Your Reference SSD-68708456 & SSD-68939460
Our Reference NCA/13/2024
Contact Bianca Lewis
Telephone 9806 5531
Email blewis@cityofparramatta.nsw.gov.au

7 April 2026

City of Parramatta Council submission to Modification Applications to Amending Concept (SSD-68939460) and Detailed State Significant Development Application (SSD-68708456) at 242-244 Beecroft Road Epping

Drawing Title
GA Elevations
Building E North Elevation

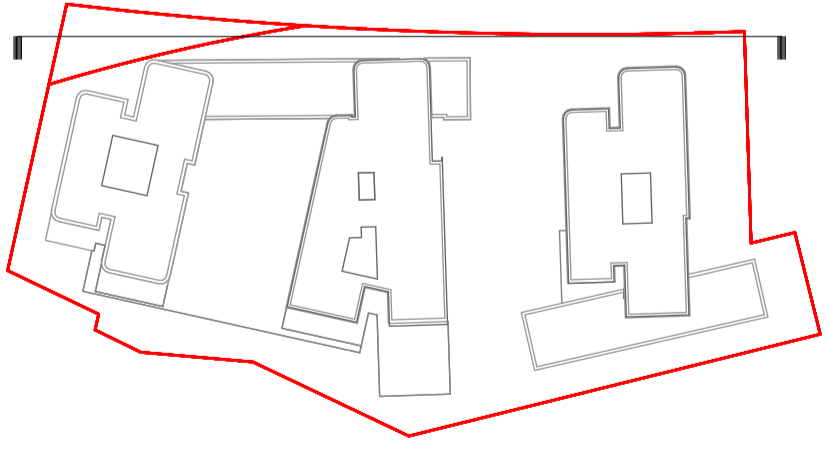
5. Council objects to the proposed reduction in the northern setback to Building E, which appears to result in a setback to be less than 6 metres (dimensions are unclear from the submitted plans). The adjoining property at 240 Beecroft Road is zoned R4 High Density Residential under the Parramatta Local Environmental Plan 2023, and in accordance the NSW Apartment Design Guide the proposal should consider future residential uses. For a building of 18 storeys in height, the minimum setback should be 12 metres above 8 storeys. This 300mm variation results in a further erosion of visual privacy for residents within the subject site and prejudices development on the adjoining site.
